**LAND TO THE NORTH OF OLD WOKING ROAD AND EAST OF STATION APPROACH, WEST BYFLEET, WOKING, SURREY, KT14 6FD  
APPLICATION FOR A NON-MATERIAL AMENDMENT TO RESERVED MATTERS APPROVAL (PLAN/2022/0266)**

We enclose on behalf of our client, Retirement Villages Group Ltd (“the Applicant”), a Non-Material Amendment (“NMA”) application which seeks to amend the approved plans under condition 2 attached to the Reserved Matters Approval (PLAN/2022/0266) dated 09 May 2022.

This NMA application seeks to amend the approved plans set out under condition 2. Following a review of the technical design of the proposed development, it has become necessary to make a series of non-material design changes to the approved scheme.

WBF. -2012 REV C

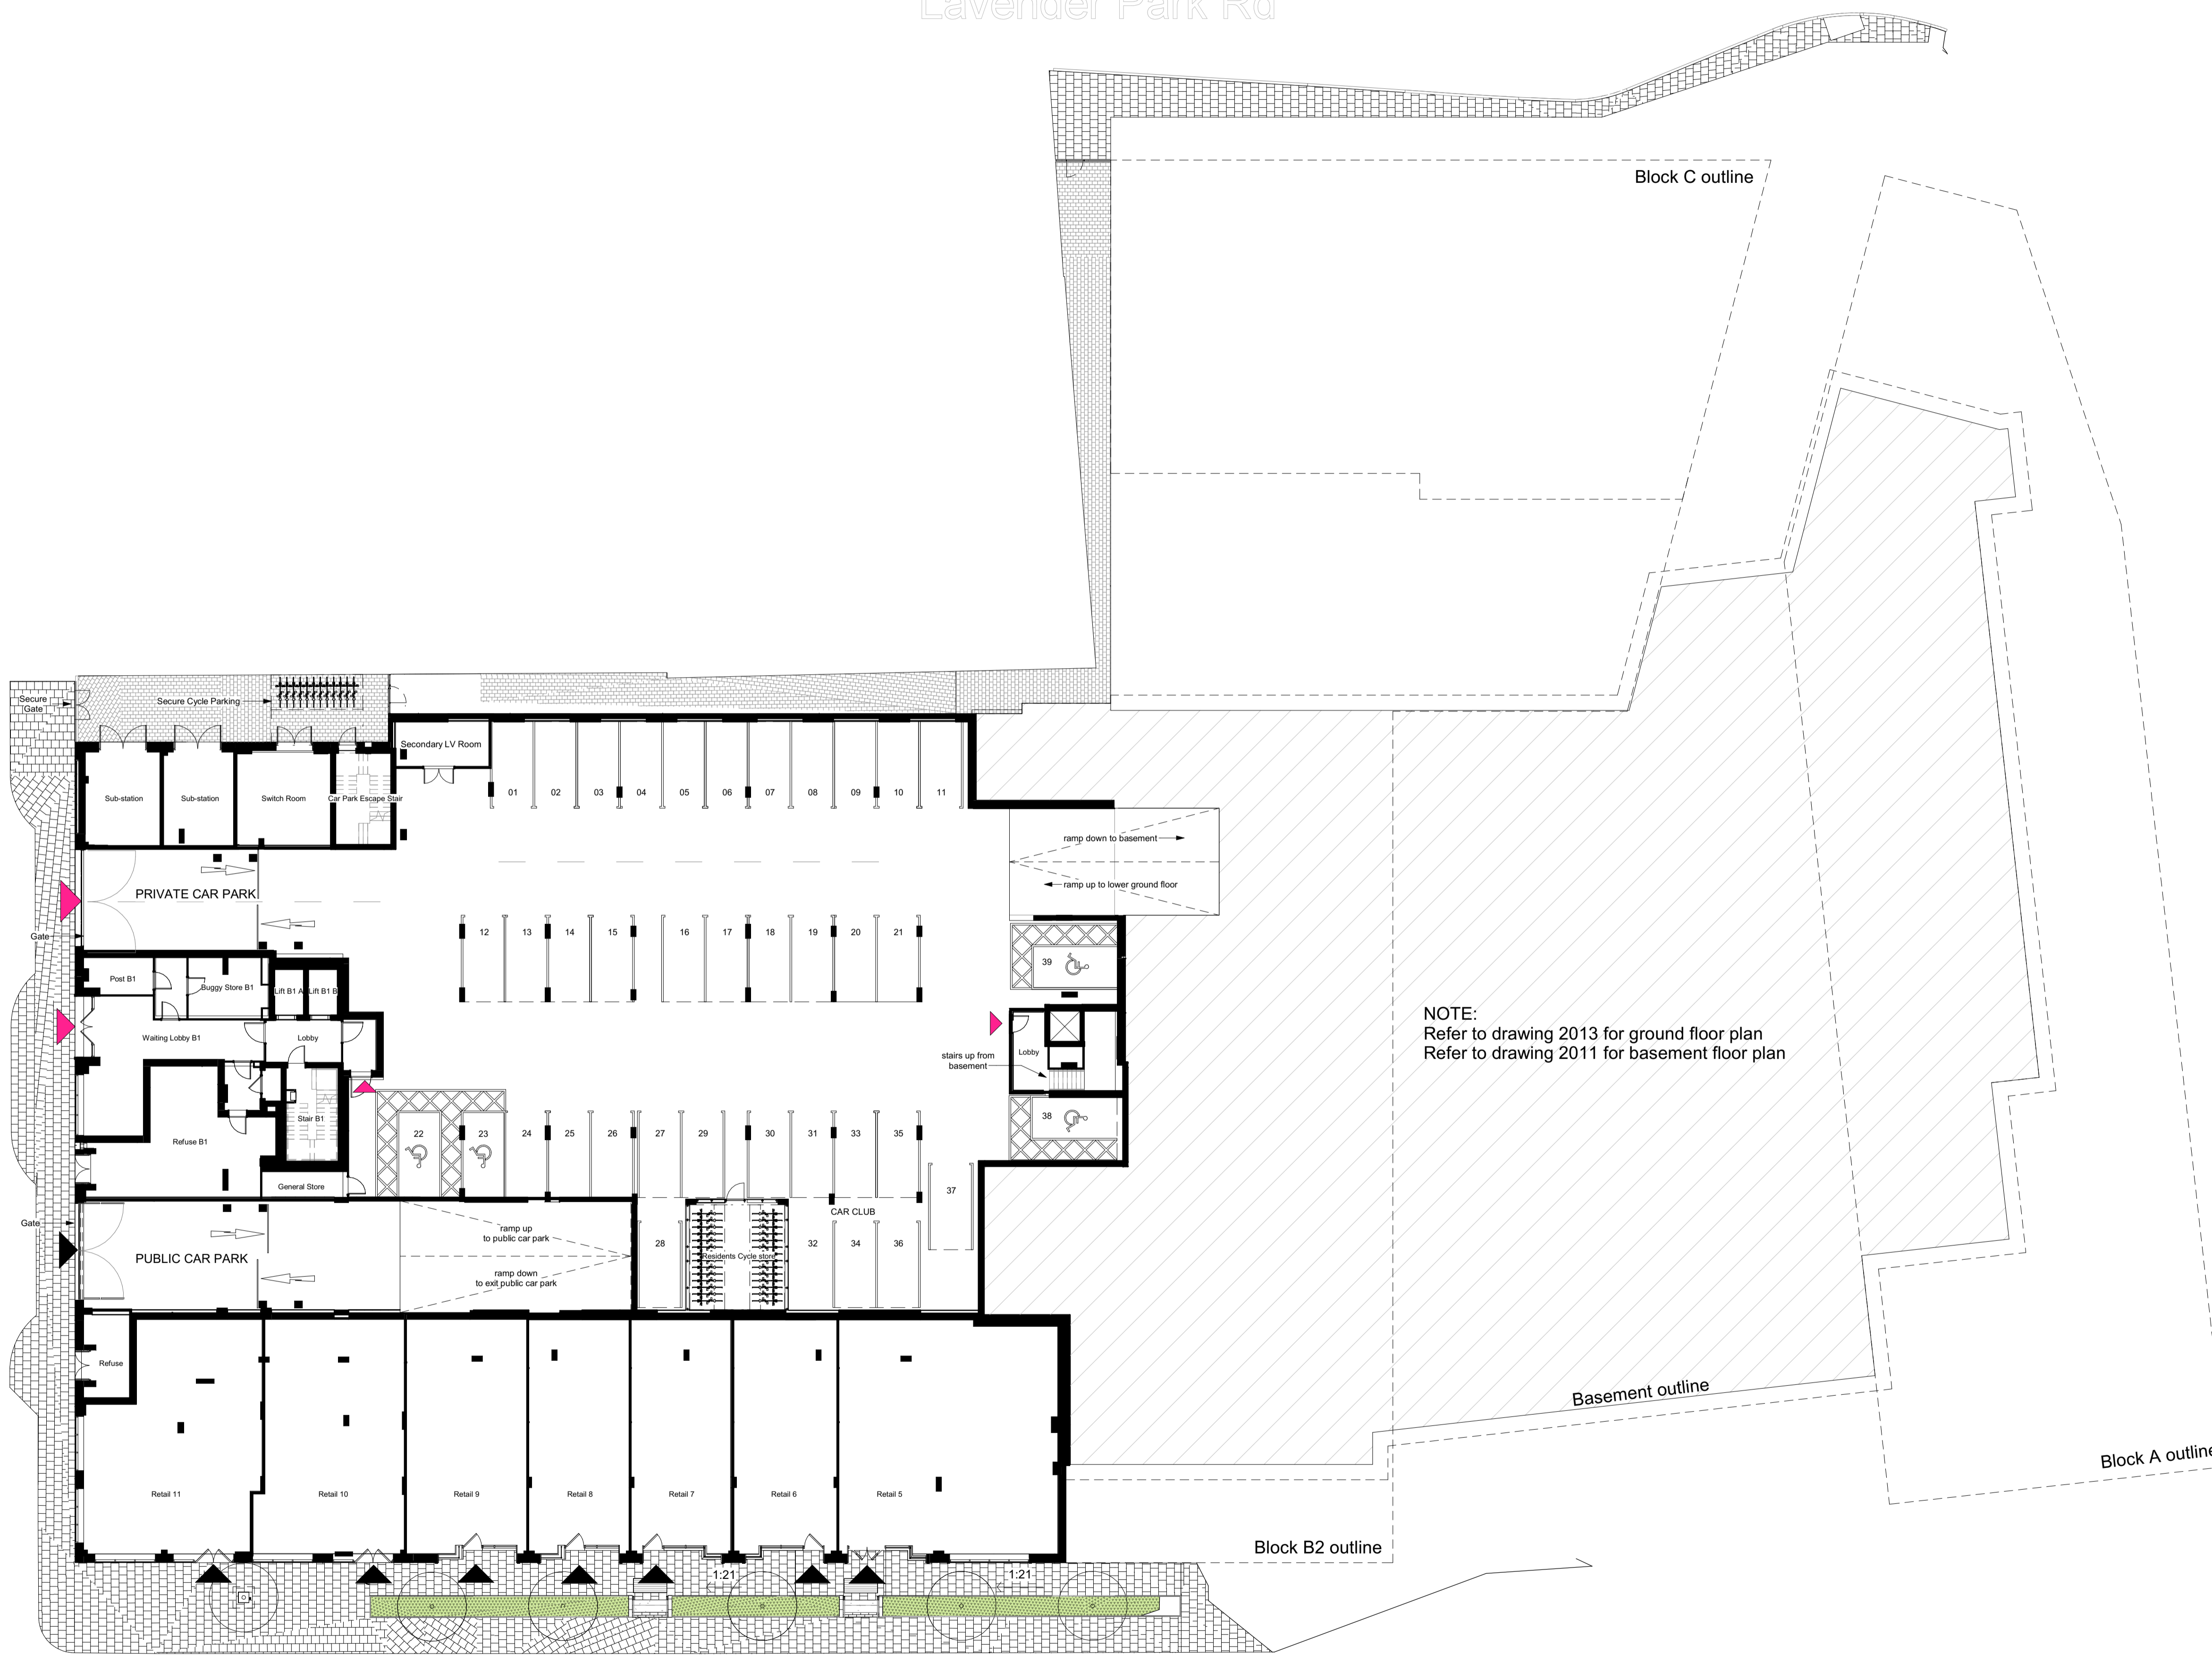
- The entrance doors and screen to the Waiting Lobby B1, which faces Madeira Road has changed to outward opening and recessed into façade. This design change is necessary to avoid doors opening onto footway.

- The doors to the two refuse stores facing onto Madeira Road have been amended to outward opening and recessed into facade to once again avoid doors opening onto the footway.

- A secondary low voltage room has been added into the private car park due to electrical design requirements. This has resulted in the loss of the minibus parking space and an additional parking space in order to accommodate the required LV room. The total number of car parking spaces within the proposed development now totals 39. It should be noted that the provision of car parking spaces is still within the parameters of the first Reserved Matters application (PLAN/2021/0059) and the most recent Reserved Matters Application (PLAN/2021/0059) – which this NMA is seeking to amend.

- The residents' cycle store location has been moved and parking bays amended due to lack of headroom in the previous location under the ramp.
- The angled splays to the walls in the private car park entrance have been omitted and made 90 degrees due to being unnecessary.
- The substation has been divided into two rooms due to electrical and technical design requirements.
- Refuse B1 room layout has been amended and a new store has been added due to refuse space planning requirements.
